FLYING HORSE NORTH SKETCH PLAN

FLYING HORSE NORTH SKETCH PLAN
COVER SHEET

COUNTY FILE NUMBER: SKP223

FLYING HORSE NORTH SKETCH PLAN
COVER SHEET

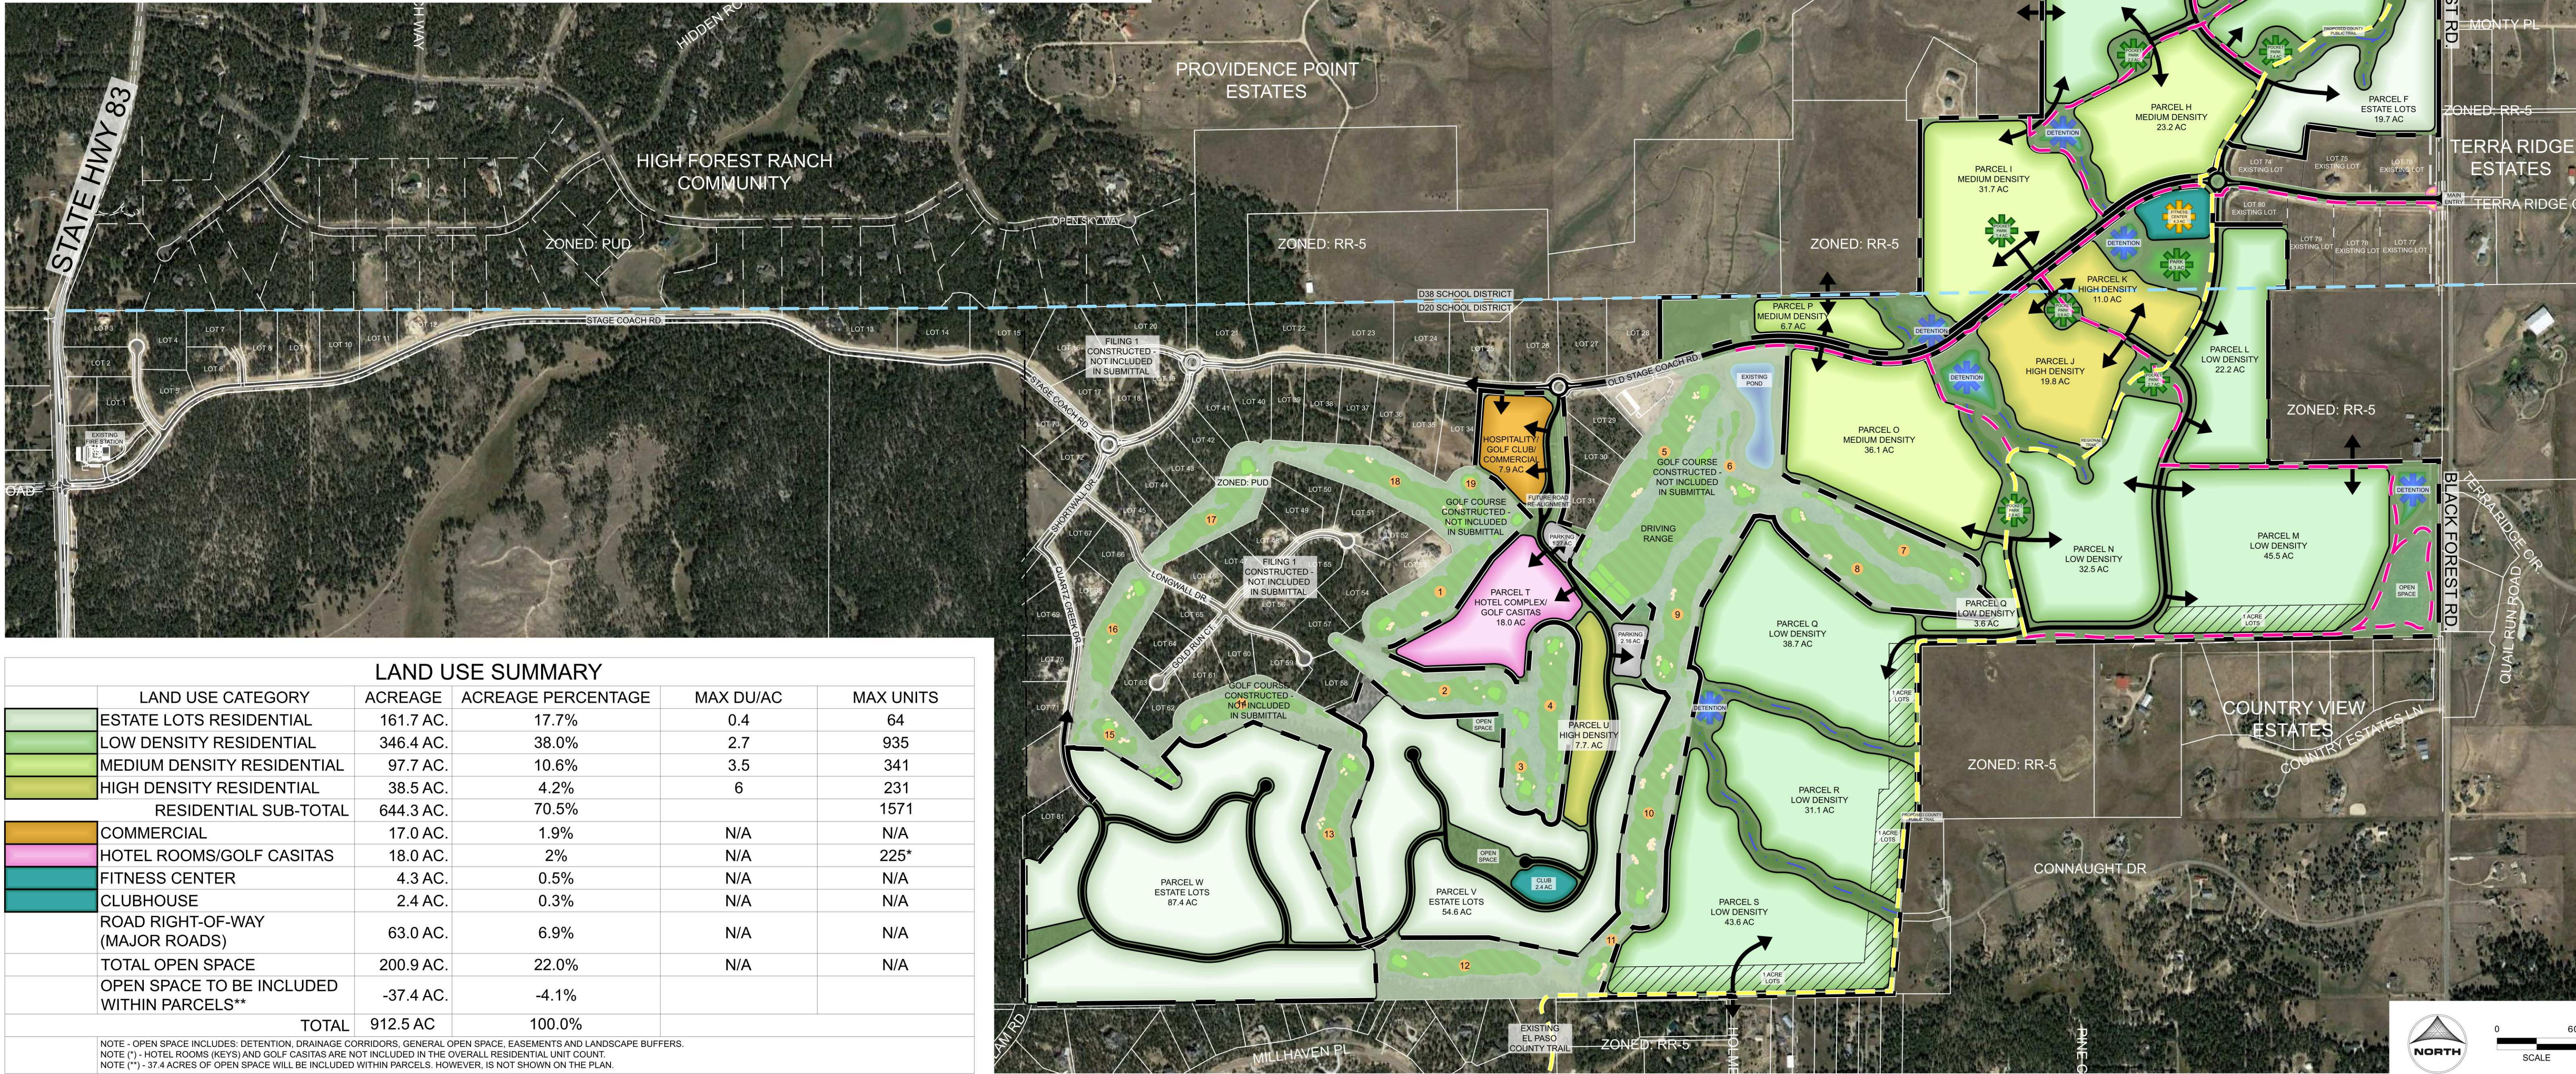
This zoning map appears to be outdated. Much of this property is currently zoned PUD through Resolution 16-442 (PUD-16-002)

FLYING HORSE NORTH SKETCH PLAN
SKETCH PLAN DRAWING

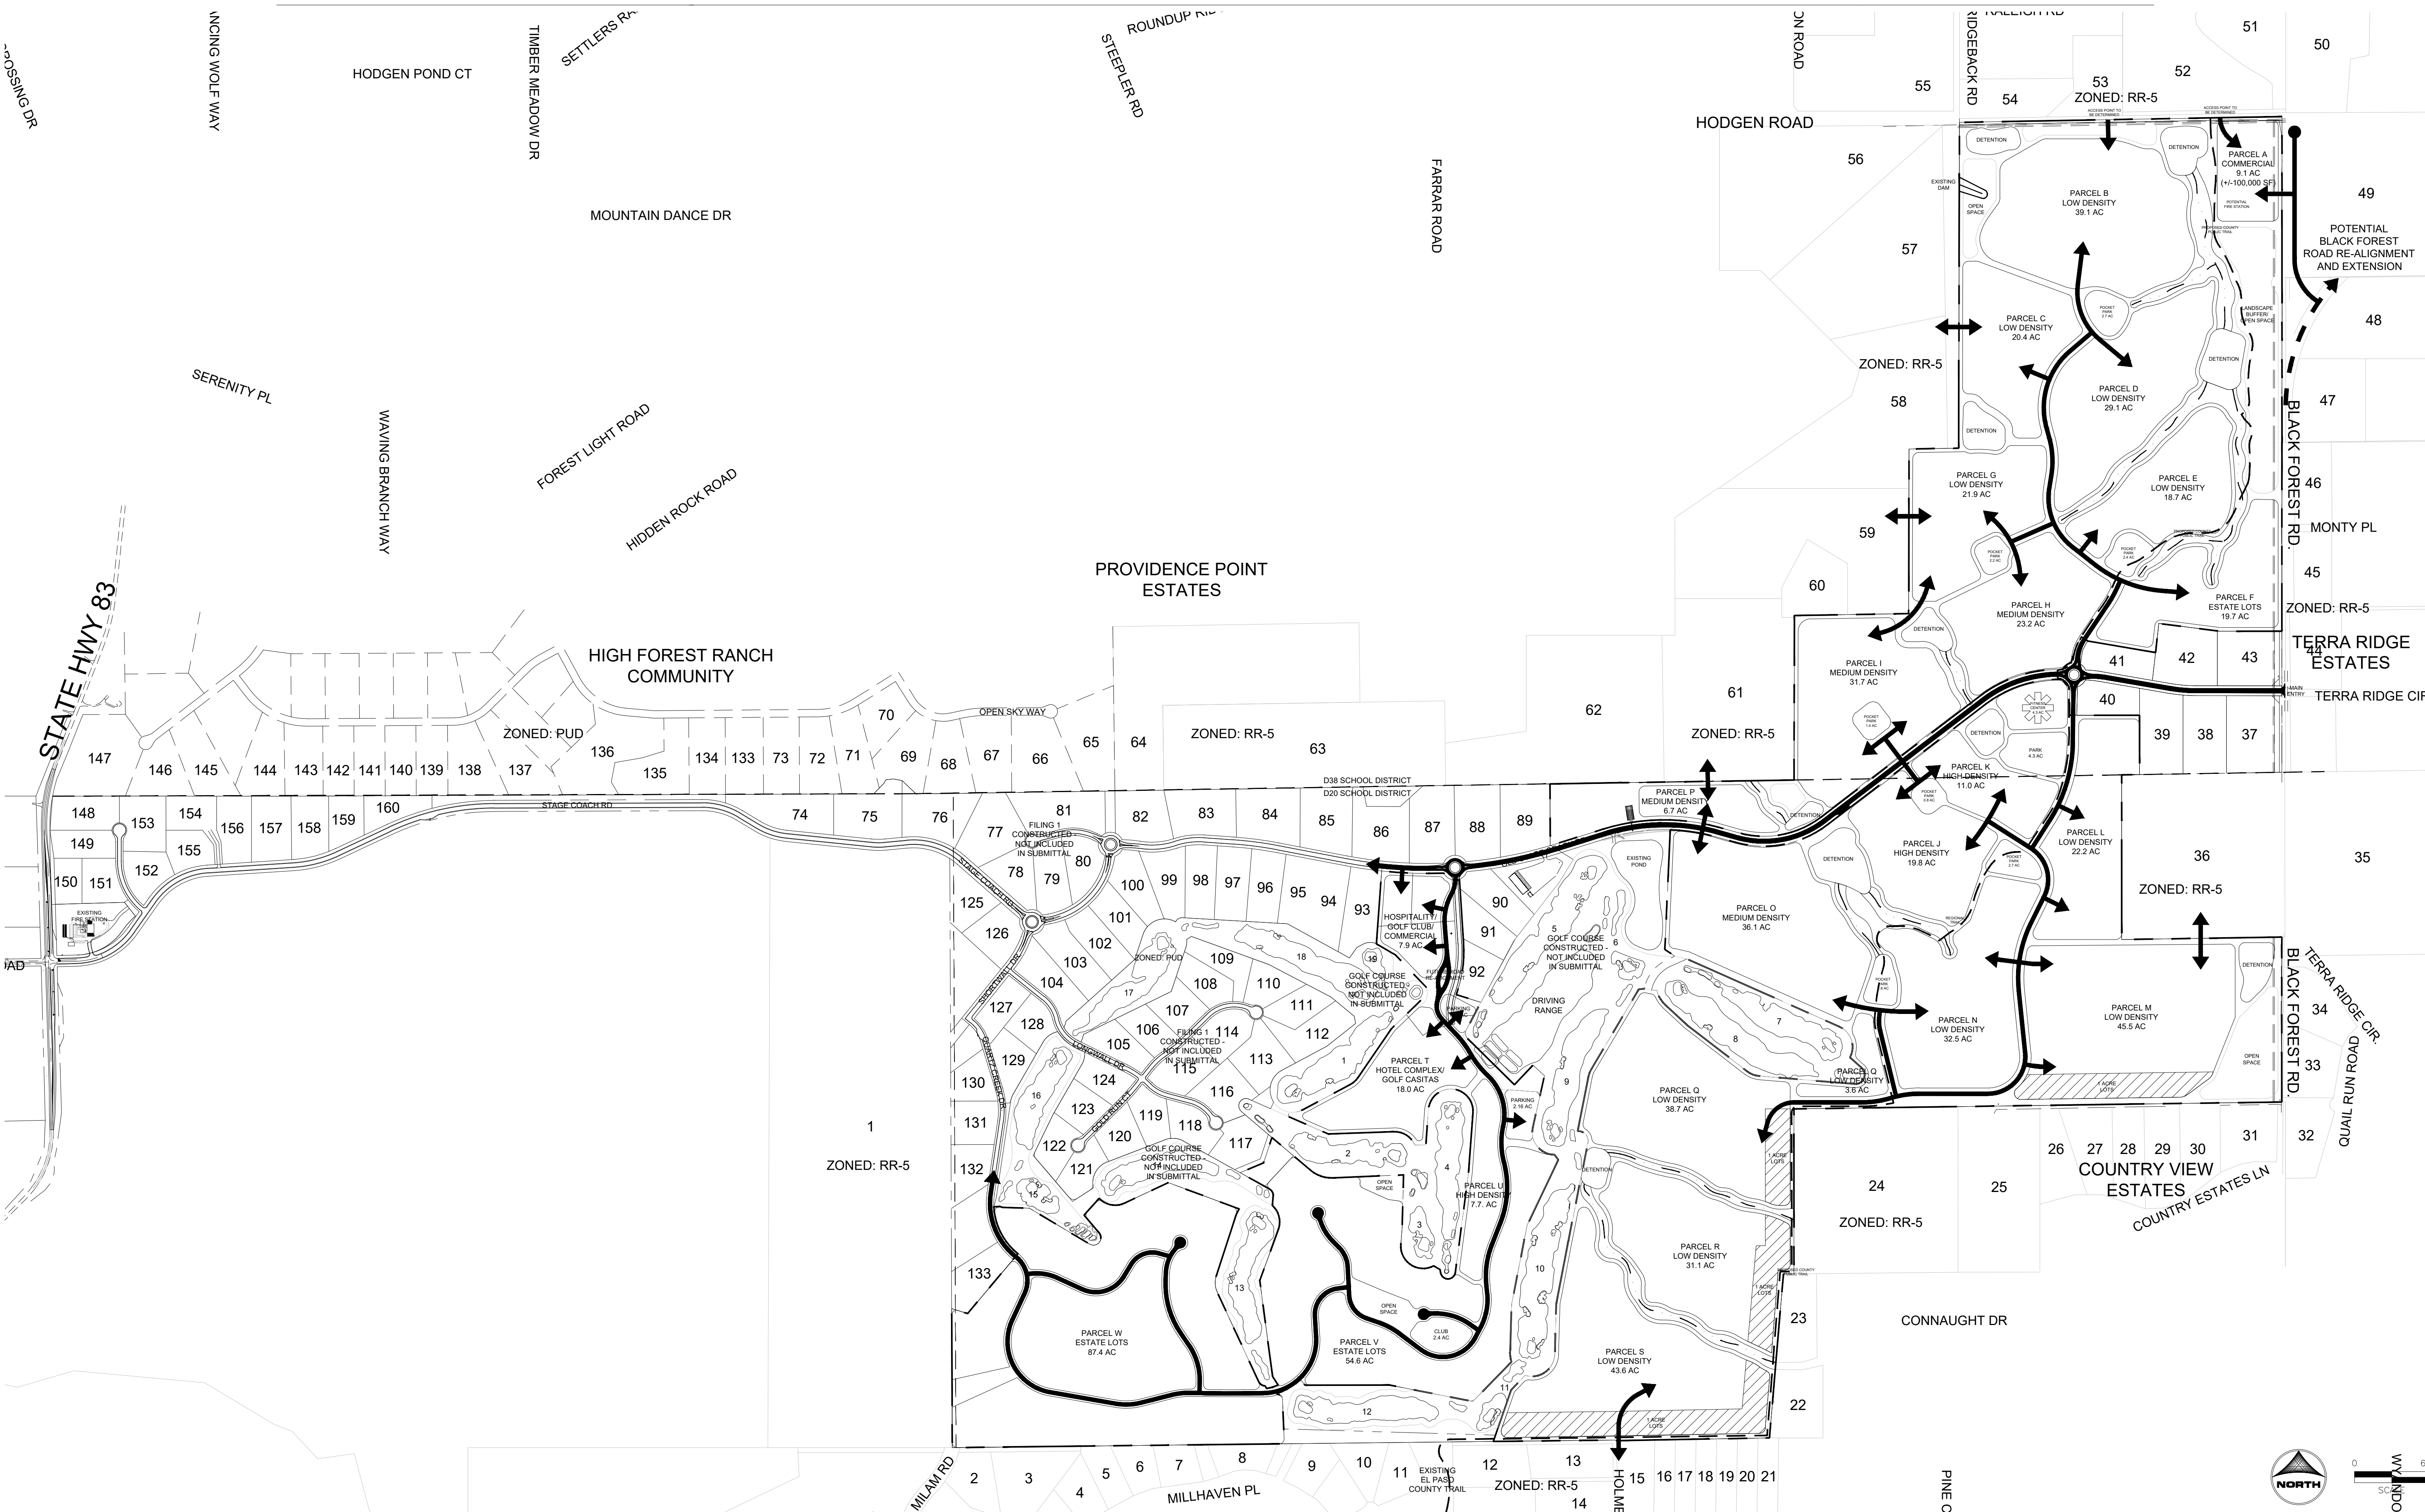
Recommend reviewing the Hodgen Rd access Management Plan (snippet to the left) and showing the connection from Hodgen Rd w/ potential cul-de-sac at the south when Black Forest Rd realignment occurs.

Unresolved. Show a single access arrow in conformance with the access management plan

Correct zoning for this area should be PUD
